Date: 27-Oct-2025
Our Ref: 2025/92375

Application for a non-material amendment following a grant of planning permission, Town and Country Planning Act 1990

**Non material amendment to previous permission 2023/91049 for demolition of detached garage and single storey lean-to extension and erection of one detached dwelling with associated parking and landscaping
47, Turnshaws Avenue, Kirkburton, Huddersfield, HD8 0TJ
Application Number: 2025/92375**

Proposed Site Plan
Scale 1:200

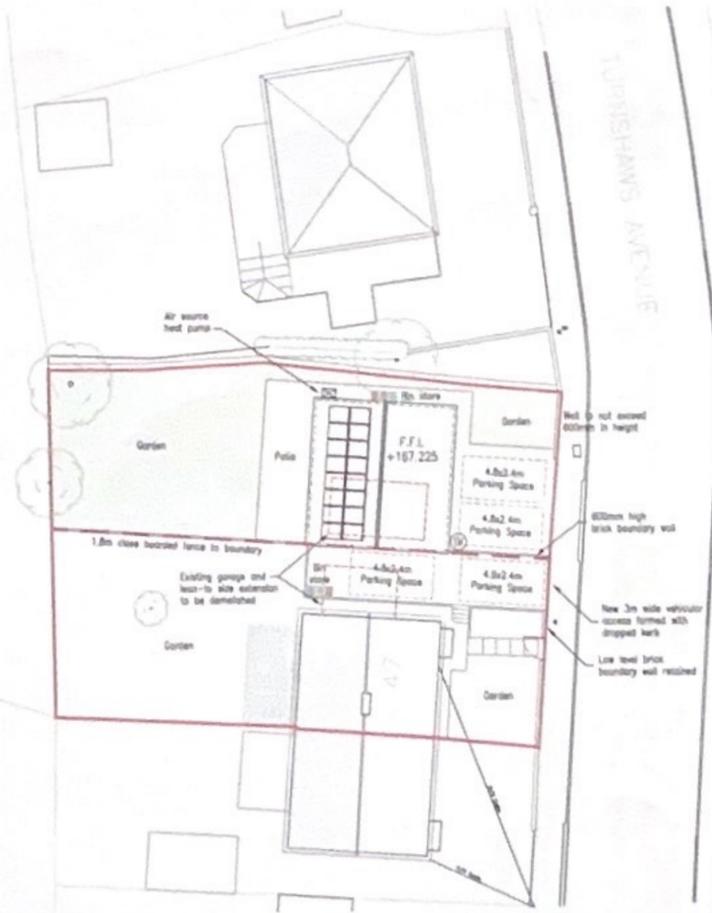
The amended parking layout is not acceptable and would not be in the interest of highway safety due to lack of space for vehicles to park. An informal discussion was also had with KC Highways who did not consider the amended parking layout to be acceptable from a highway safety perspective for this reason. In order to facilitate retention of the existing lean-to parking spaces could be provided adjacent to each other mirroring those proposed for the new dwelling. This could be regularised through the submission of a new application which will be subject to a further round of publicity and consultation.
